Ribble Valley Borough Council
Housing & Development Control

Your ref 3/2022/0218

Application no: **3/2022/0218**

Address: **Shireburn Caravan Park Edisford Road Waddington BB7 3LB**

Screenshot of Southern Access

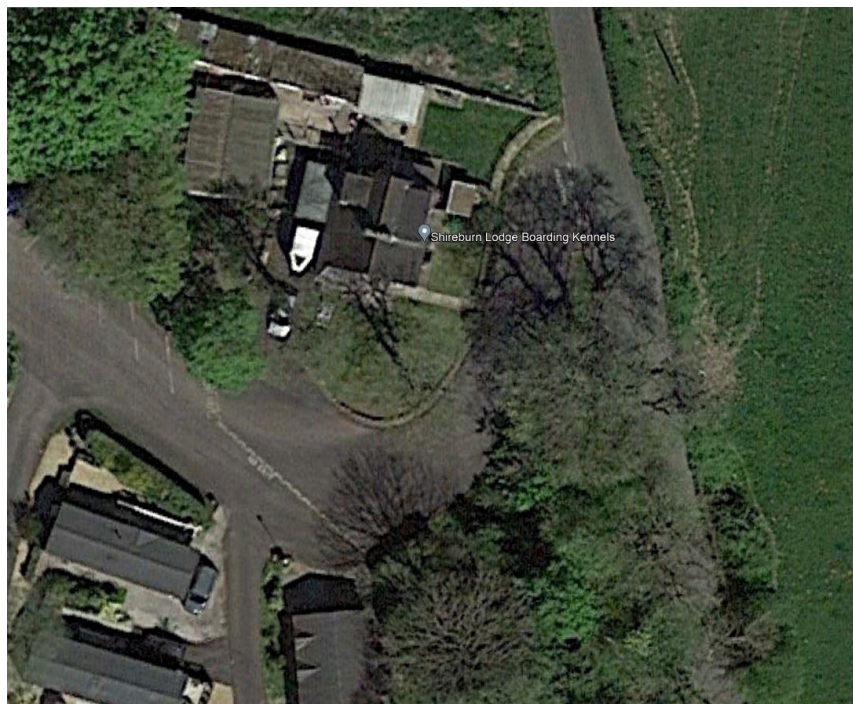
The LHA also have concerns associated with the access's vehicular visibility, as stated in the Applicants supporting document titled "Technical Note: Highways." In the document, the Transport Consultant has stated that the access can only achieve visibility splays of 8.5m to the north and 10.5m to the south, which is a considerable shortfall for the speed of the road with the LHA requiring minimum visibility splays of 214m in both directions.

The LHA do acknowledge that speeds along Edisford Road in this location are unlikely to be in excess of 60mph due to the road having natural speed calming features, including the highway being narrow and there being a slight curve in the road within the vicinity of the site. However, speeds along the road will not correlate with the provided visibility splays at the site access which is unacceptable and could be to the detriment of highway safety should the substandard access be further intensified, as this application is proposing. Therefore, the LHA object against the variation of condition.

DRAWING NO: 2200201

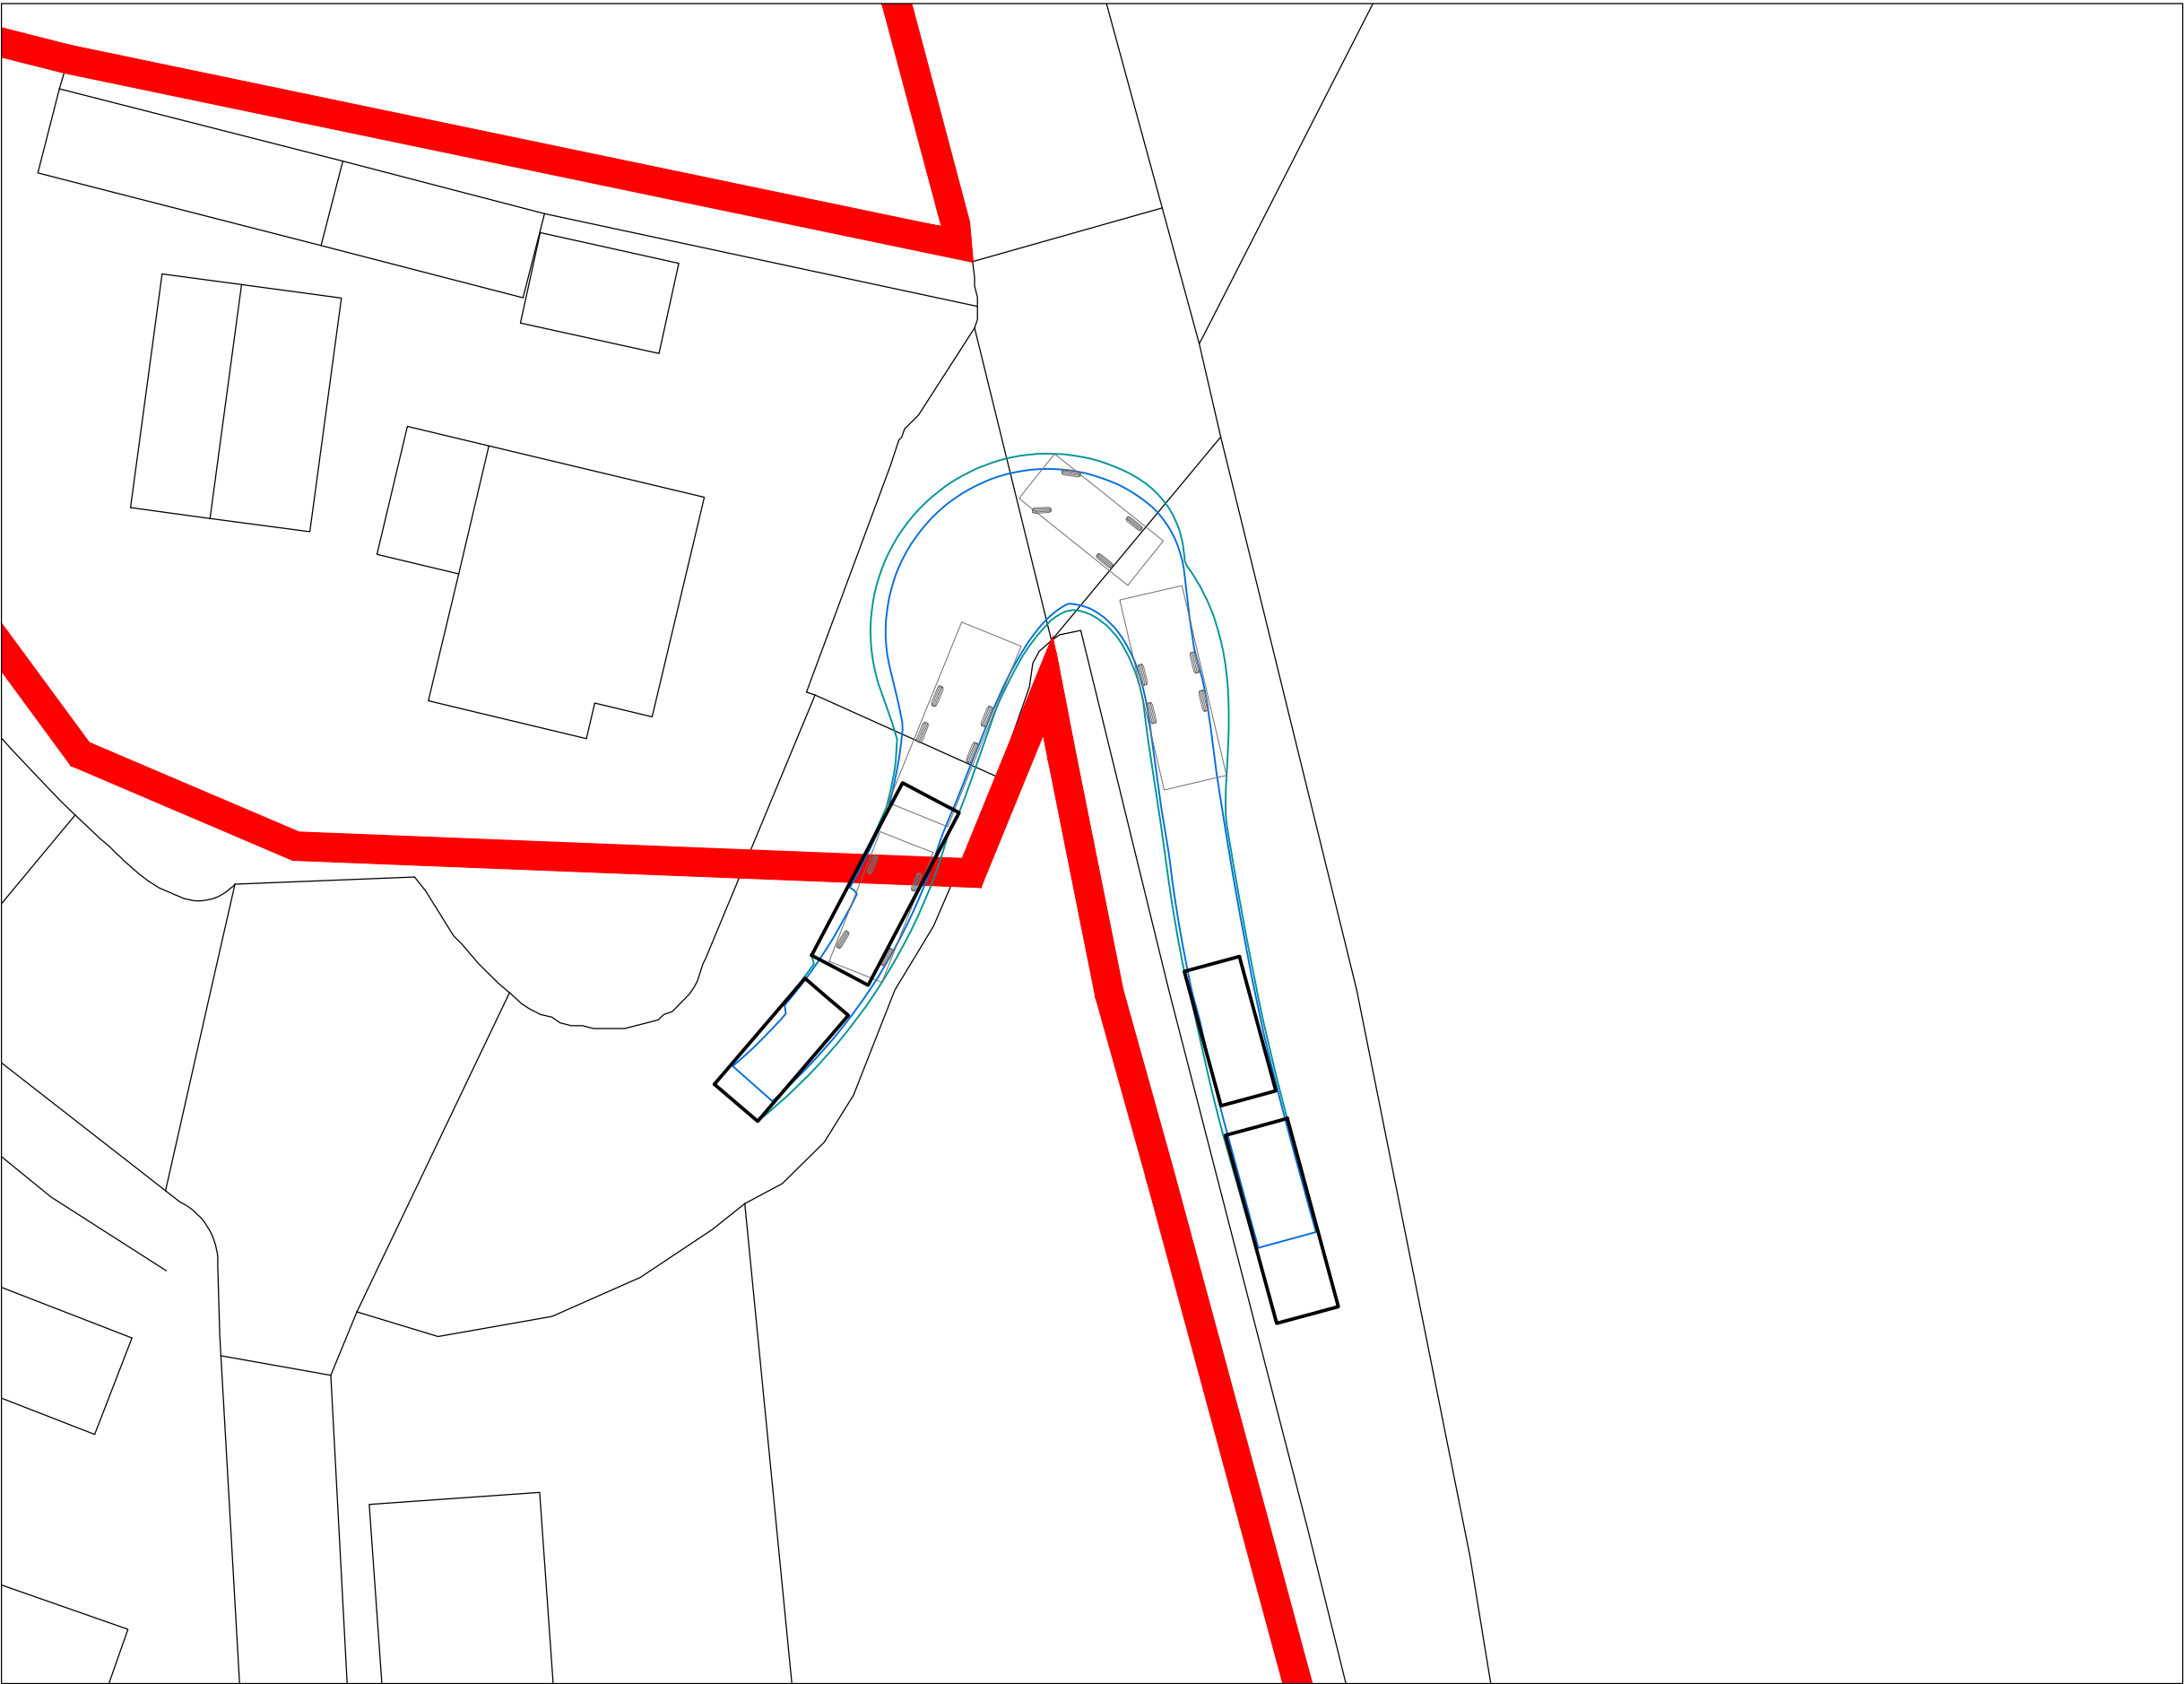
However, the LHA are aware that even though the access width complies with the LHAs guidance when serving a Caravan Park, the angle of the access and the private access track serving the site will cause vehicles to overlap both sides of the access when entering the site. This could cause potential conflicts to occur between vehicles waiting to exit the access, simultaneously, which would be to the detriment of highway safety.

The LHA are aware that the access is used to serve Shireburn Lodge Boarding Kennels, where this issue could occur. But the proposal will intensify the use of the access, making the scenario more likely to occur.
